# Bega Valley Health Services Hospital Development - Stage 2

SSD 5307 – 2012: Response to Submissions

May 2013

REV	DESCRIPTION	DATE
A	Draft Proposal	14.05.2013

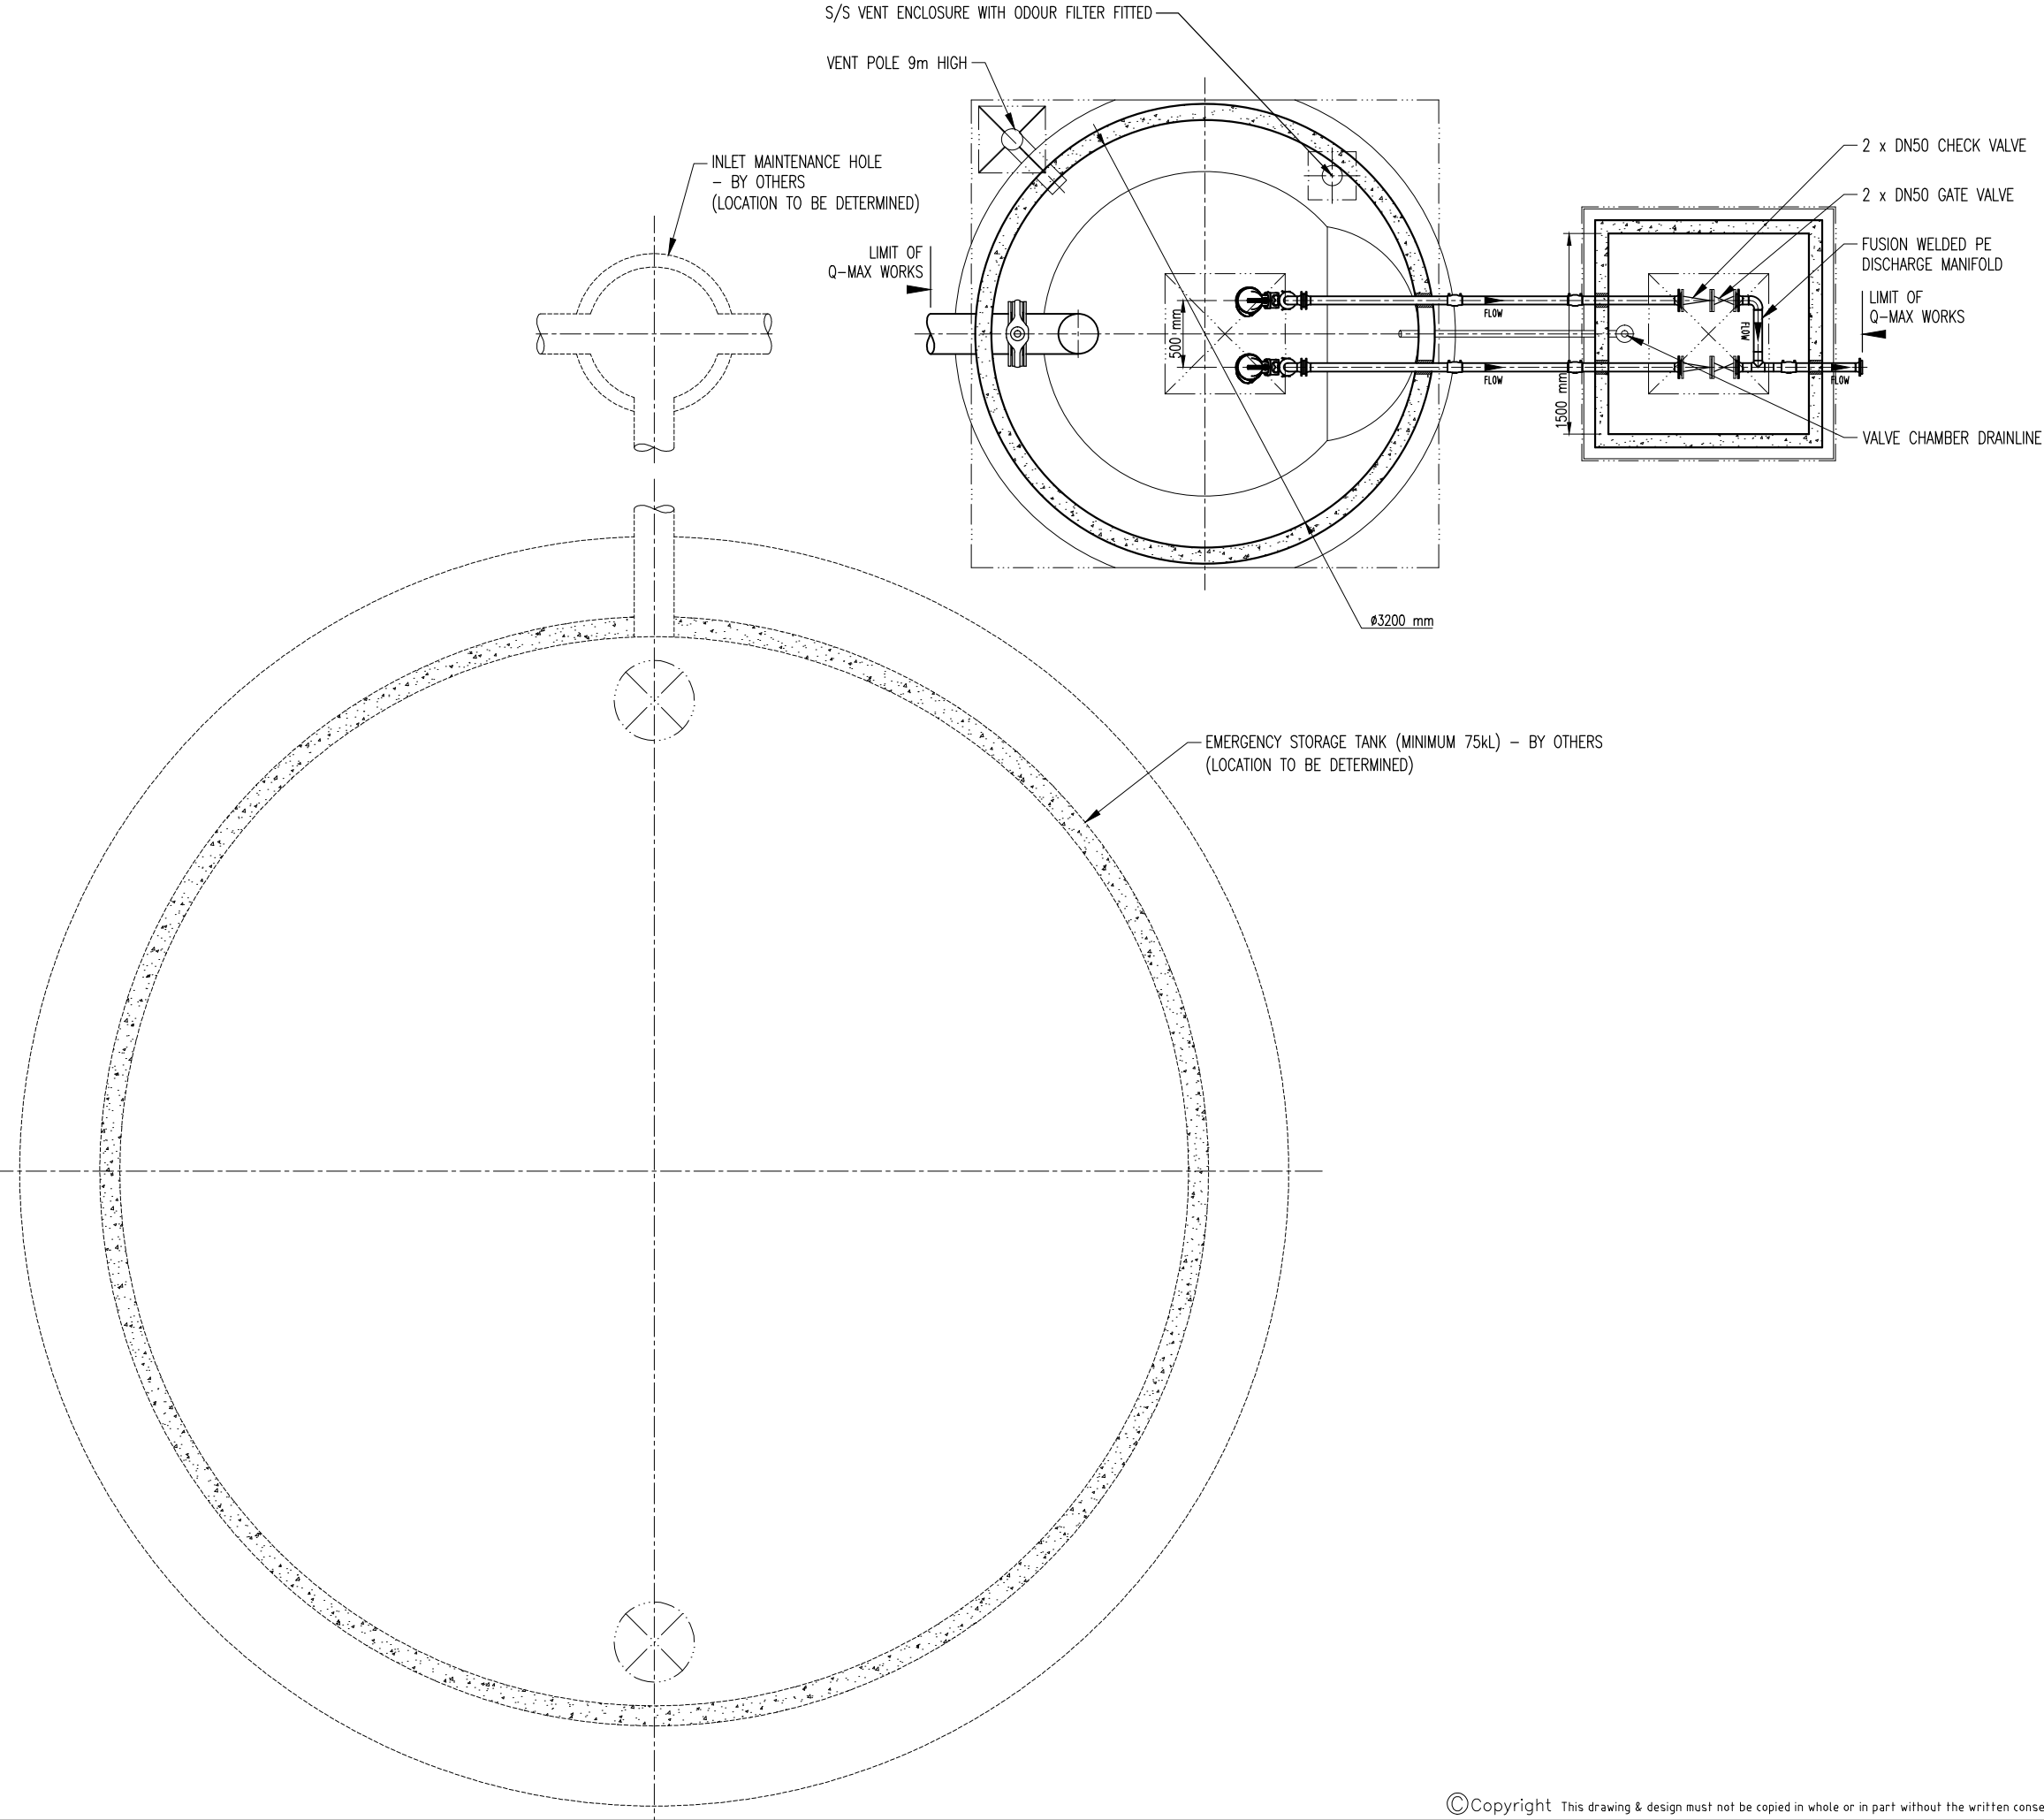
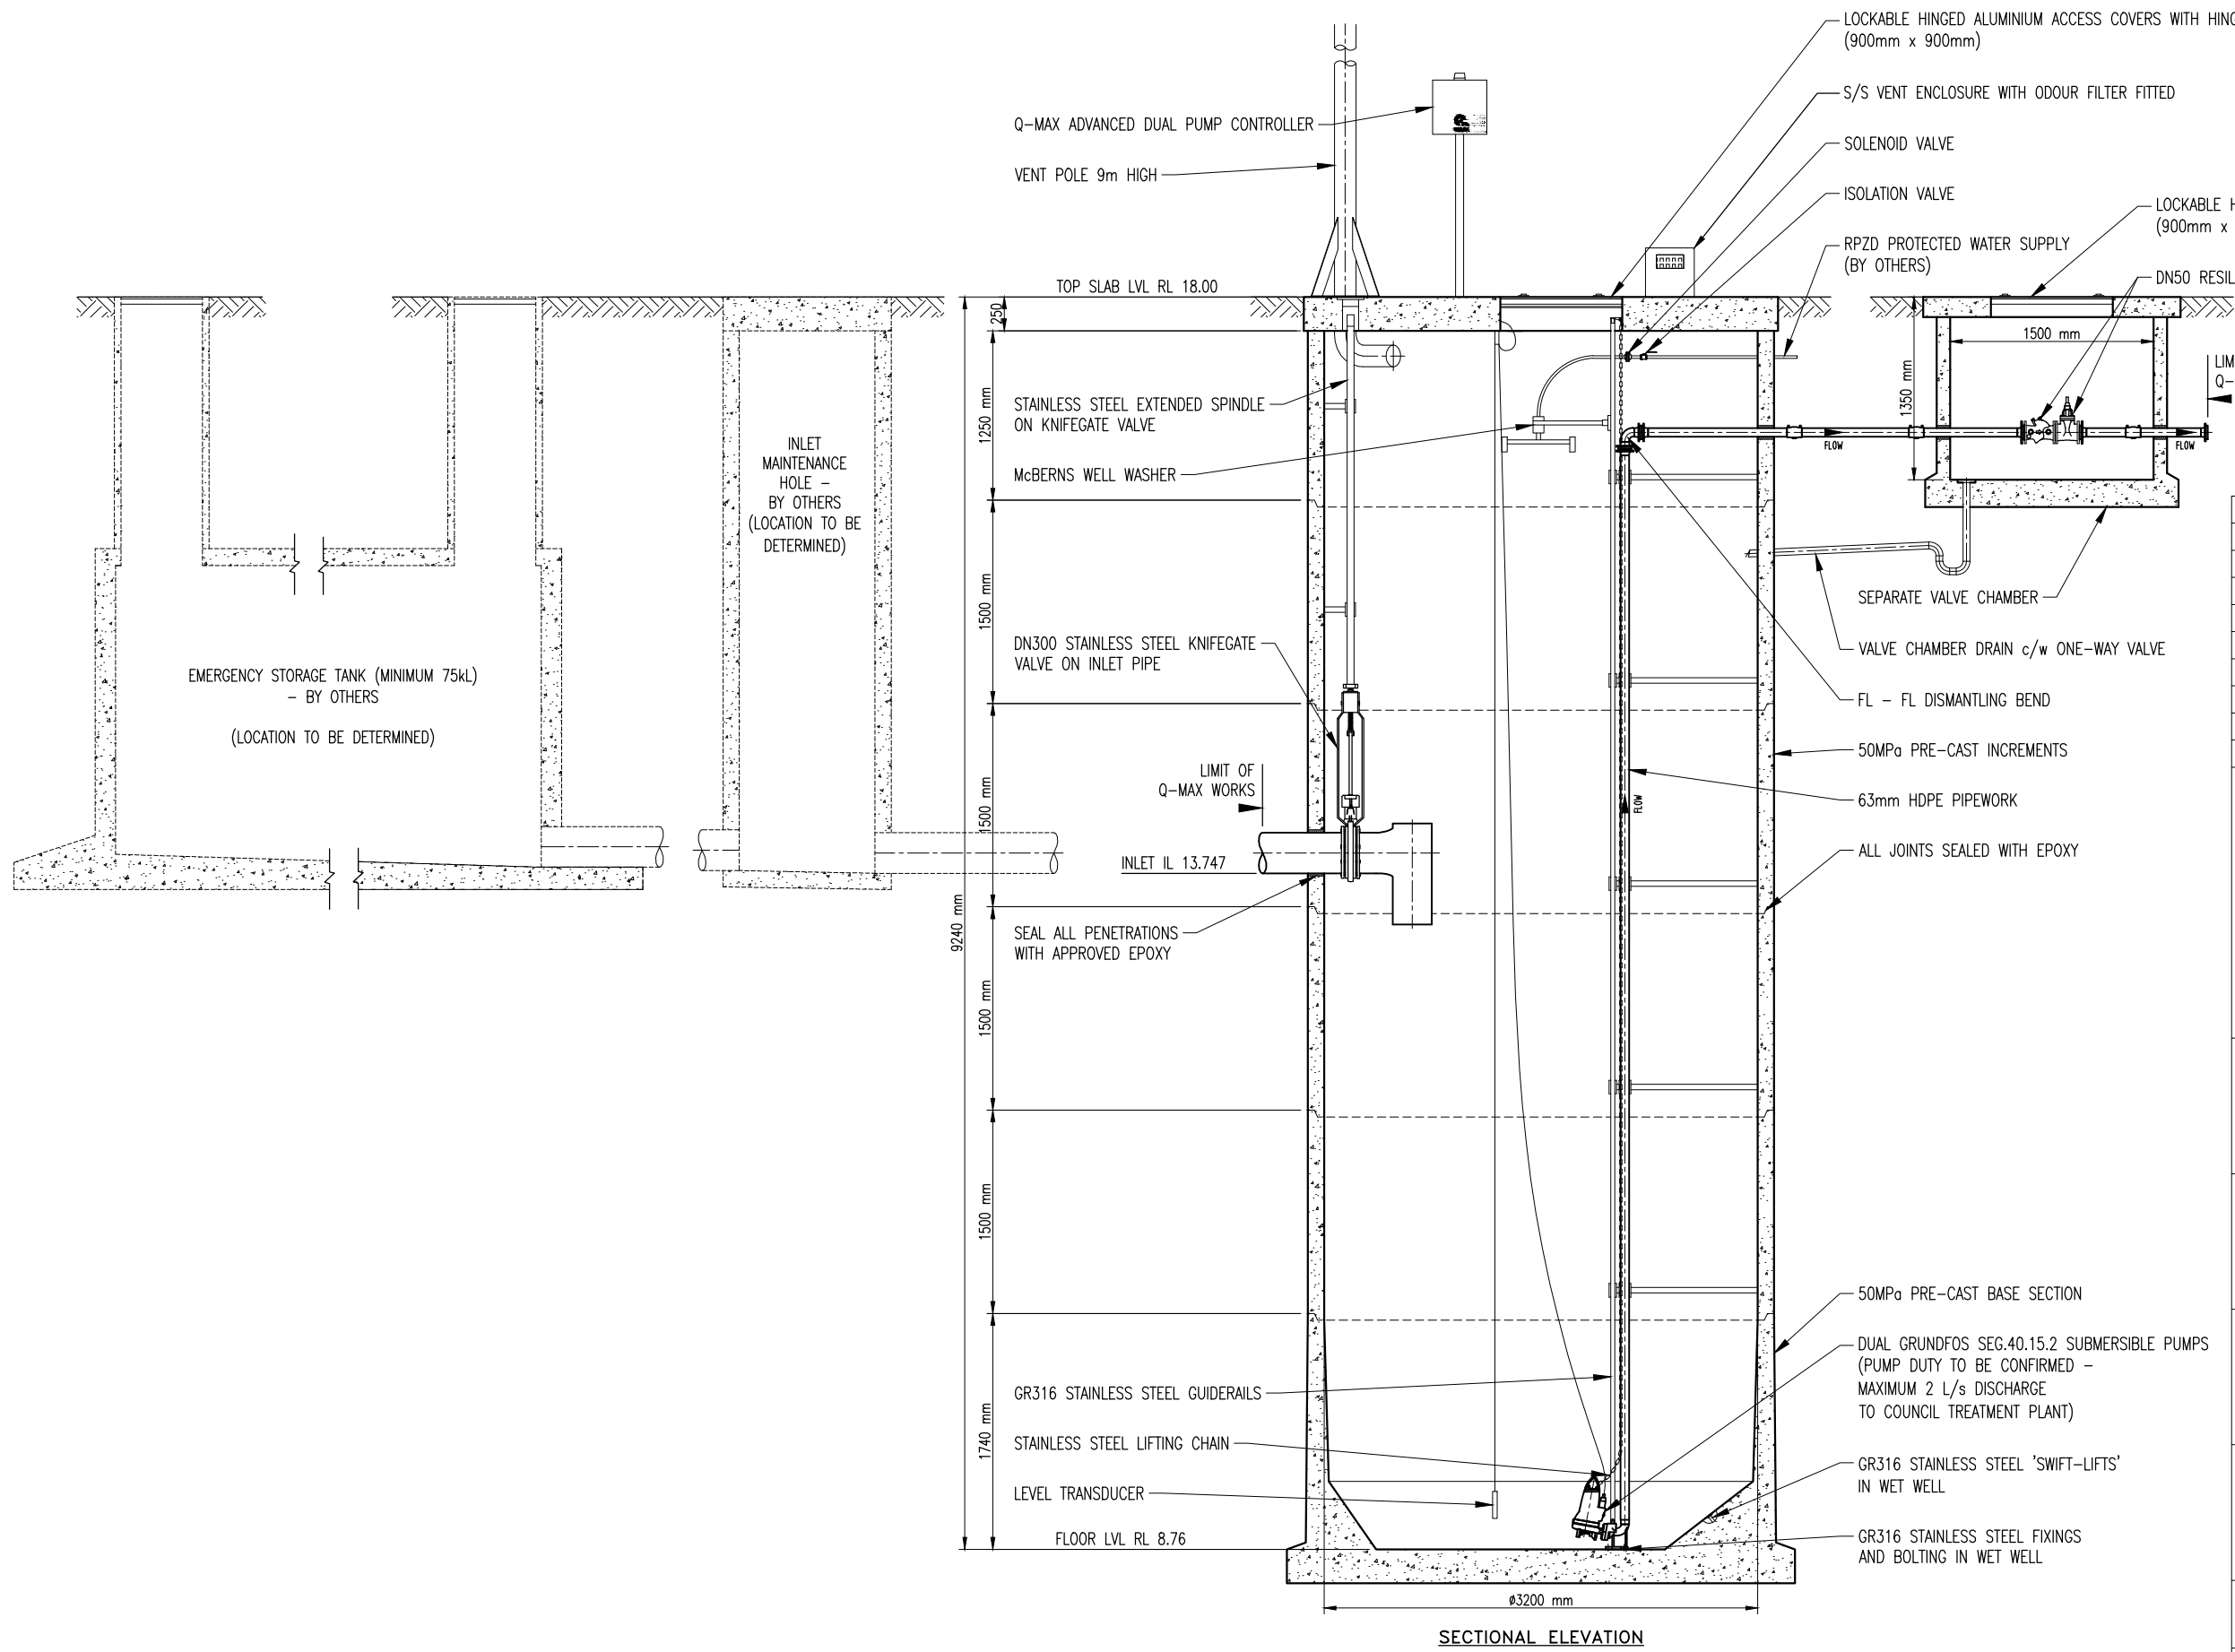
| ISSUE                                     | COMMENT                                                                                                                                                                                                                                                                                                                                                                                                                                                                                                                                                                                                                                                                                                                                                                            | RESPONSE                                                                                                                                                                                                                                                                                                                                                                                                              |
|-------------------------------------------|------------------------------------------------------------------------------------------------------------------------------------------------------------------------------------------------------------------------------------------------------------------------------------------------------------------------------------------------------------------------------------------------------------------------------------------------------------------------------------------------------------------------------------------------------------------------------------------------------------------------------------------------------------------------------------------------------------------------------------------------------------------------------------|-----------------------------------------------------------------------------------------------------------------------------------------------------------------------------------------------------------------------------------------------------------------------------------------------------------------------------------------------------------------------------------------------------------------------|
| Sewer – as per Council's formal response. | <p>Point 11 - Utilities of the Keys Issues of the Department Planning DGRs stated, 'in consultation with the relevant agencies the EIS shall address the existing capacity and any augmentation requirements of the development for the provision of utilities including staging of infrastructure through the preparation of an Infrastructure Management Plan'.</p> <p>A review of the EIS has identified that no Infrastructure Management Plan or any other information addressing the existing capacity of sewer or the proposed capacity of sewer for the proposed hospital has been provided. Council is unable to determine augmentation requirements for the development and therefore unable to adequately assess the impacts on Sewer Utilities by the development.</p> | <p>Health Infrastructure has engaged in discussion with BVSC in relation to the existing and proposed sewer capacity. As a result of these discussions Health Infrastructure are in the process of preparing an Integrated Water Management Plan (prepared by WSP Consultants) which will inform future discussion with BVSC.</p> <p>Details of the proposed Sewer Pump System are attached at <b>Appendix E</b>.</p> |
